**SECTION 4.55(1A) MODIFICATION APPLICATION – SSD 8892218
BUILDING R4B, ONE SYDNEY HARBOUR, BARANGAROO SOUTH**

This modification application has been prepared by Ethos Urban on behalf of Lendlease (Millers Point) Pty Ltd, pursuant to section 4.55(1A) of the *Environmental Planning and Assessment Act 1979* (EP&A Act) to modify Development Consent SSD 8892218 relating to Building R4B Barangaroo South (the site).

LEVEL	RL
R4B L63	219.005
R4B L62	215.545
R4B L61	212.085
R4B L60	208.625
R4B L58	201.705
R4B L57	198.245
R4B L56	194.785
R4B L55	191.325
R4B L54	187.865
R4B L53	184.405
R4B L52	180.945
R4B L51	177.485
R4B L50	174.025
R4B L49	170.885
R4B L48	167.745

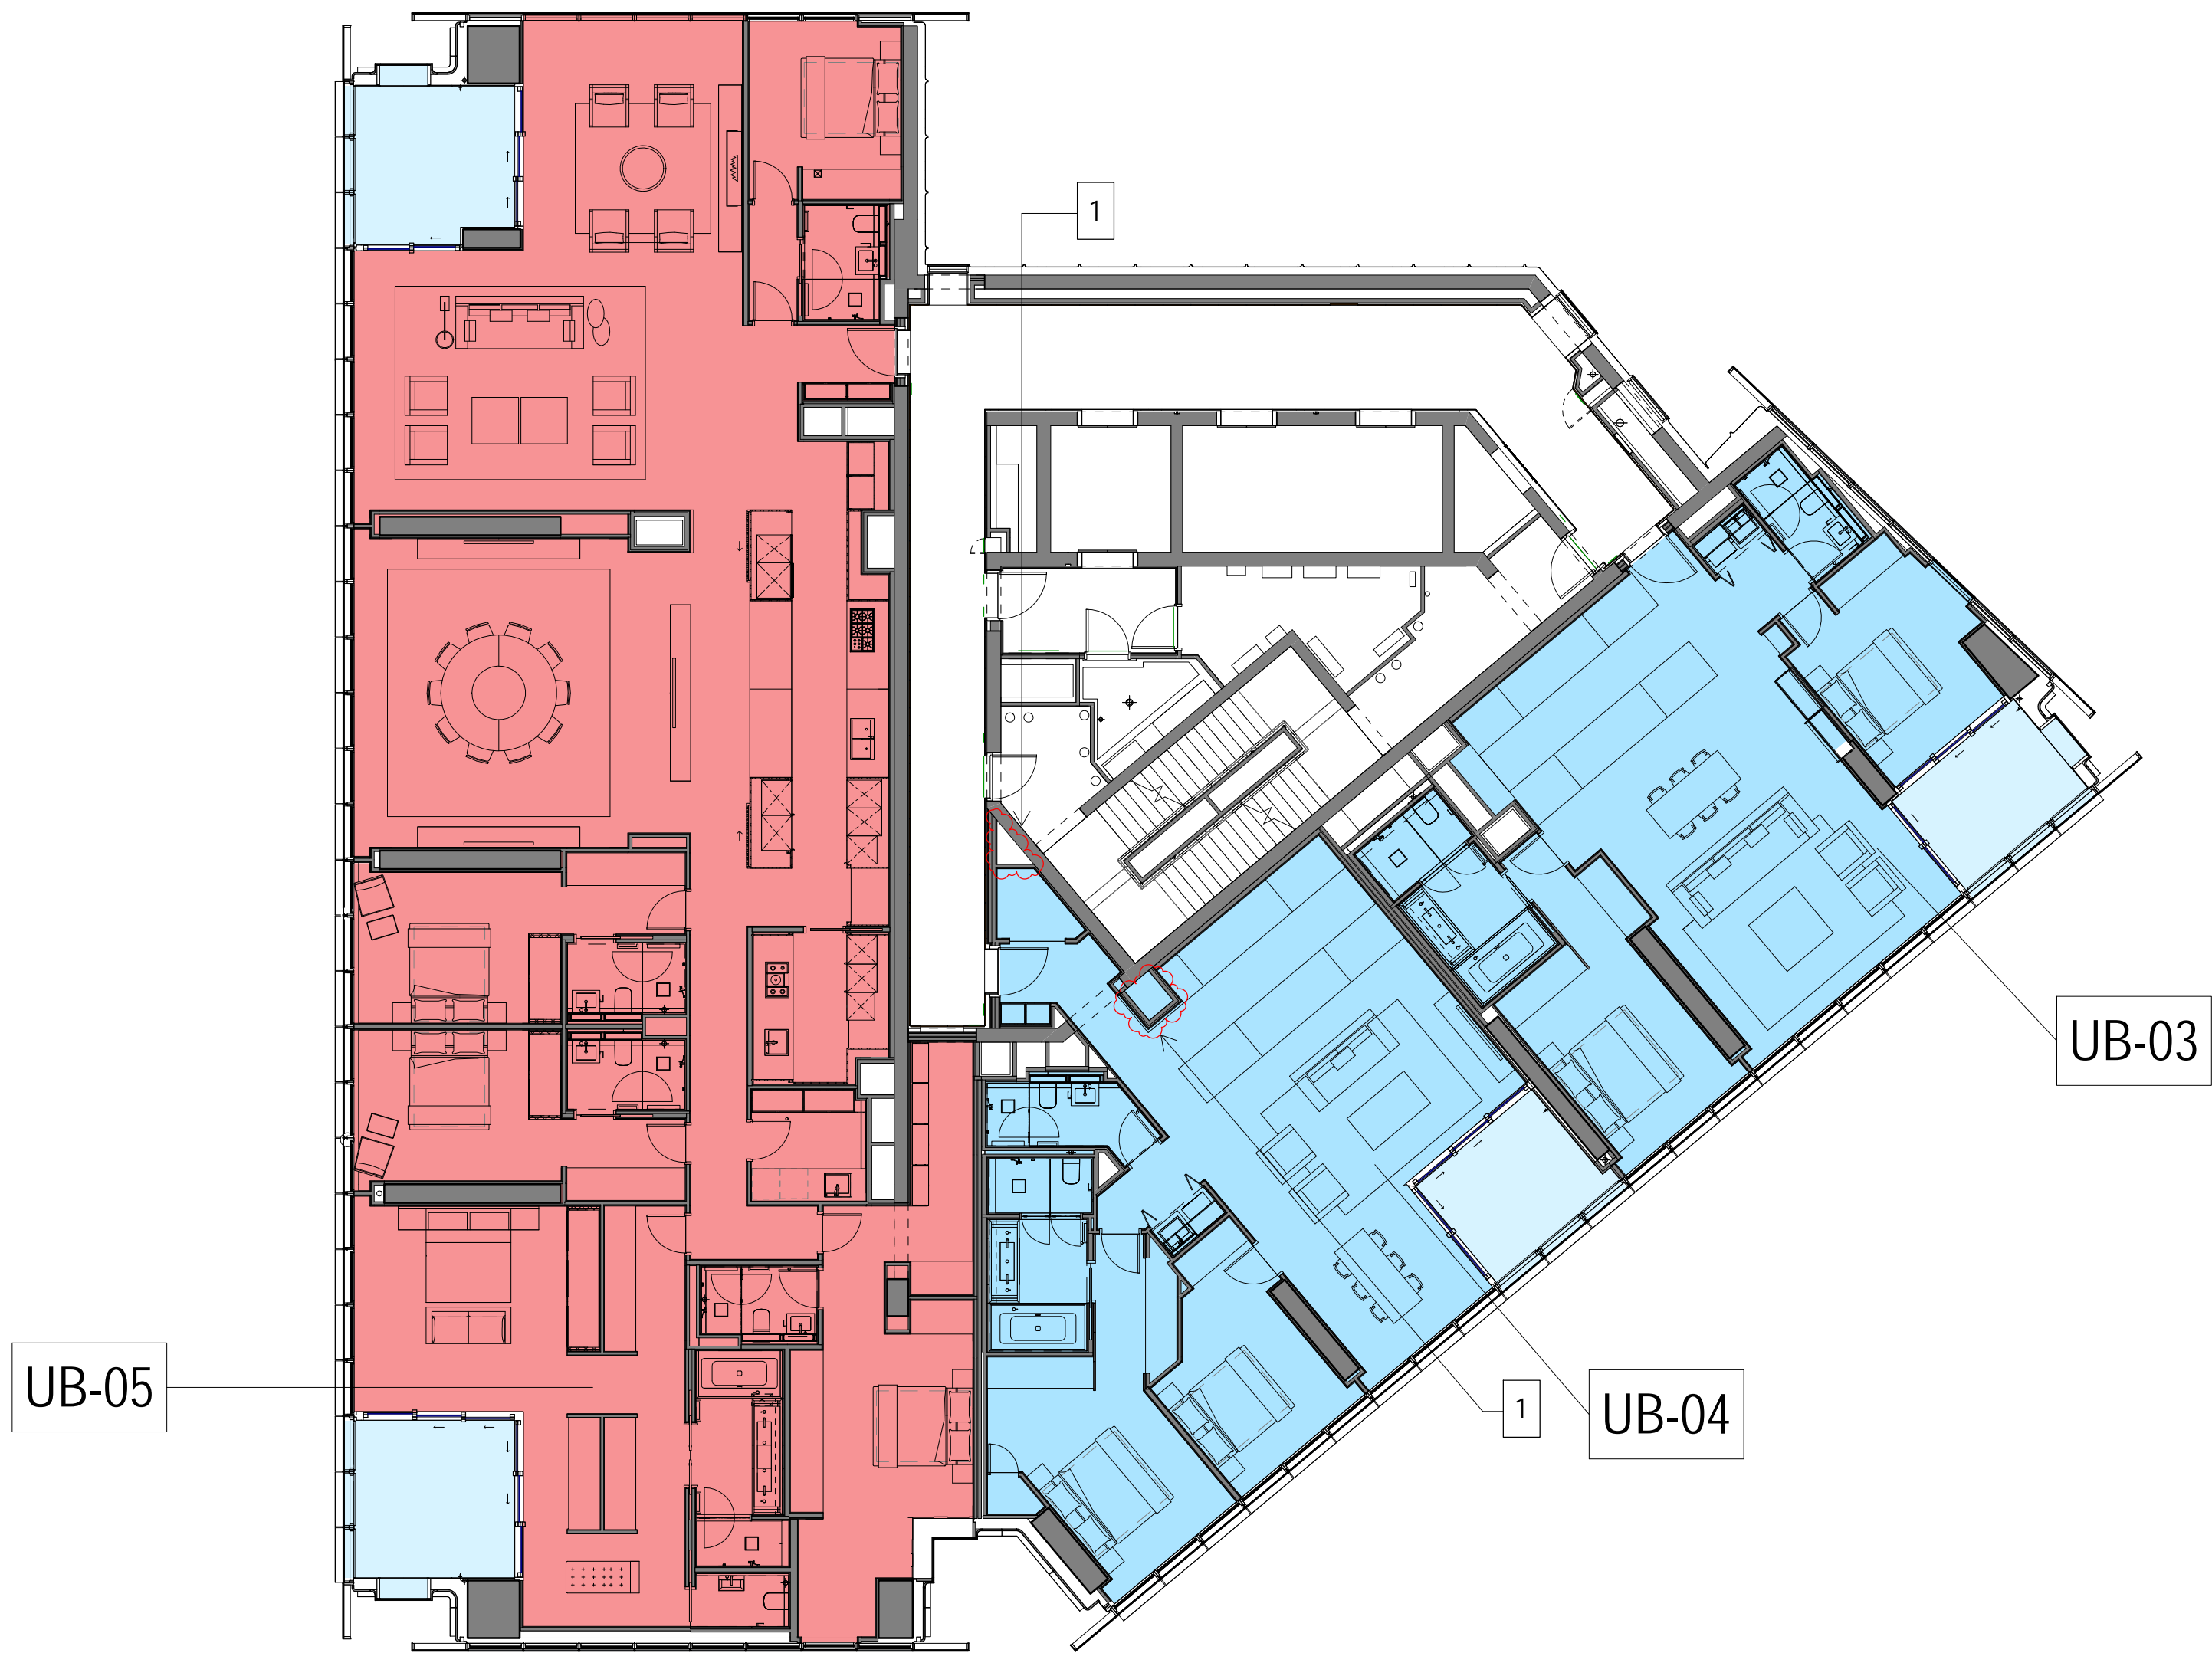
- Wall adjustments in apartment type UB-04 on level 48-58 and 60-63.
- Wall adjustments in apartment type UB-04 on Level 59.

These amendments occur in the subject apartment type storage room areas in response to further design refinements. The amendments involve 'squaring off' the acute point of the storage rooms, allowing for a more functional and accessible storage space within the apartments.

In response to the reshaping of these storage spaces, there is minor floor area redistribution within the apartments. Notwithstanding, it is noted that this does not result in any changes to the apartments floor areas or the building total gross floor area. These amendments are shown in **Figure 2** below.
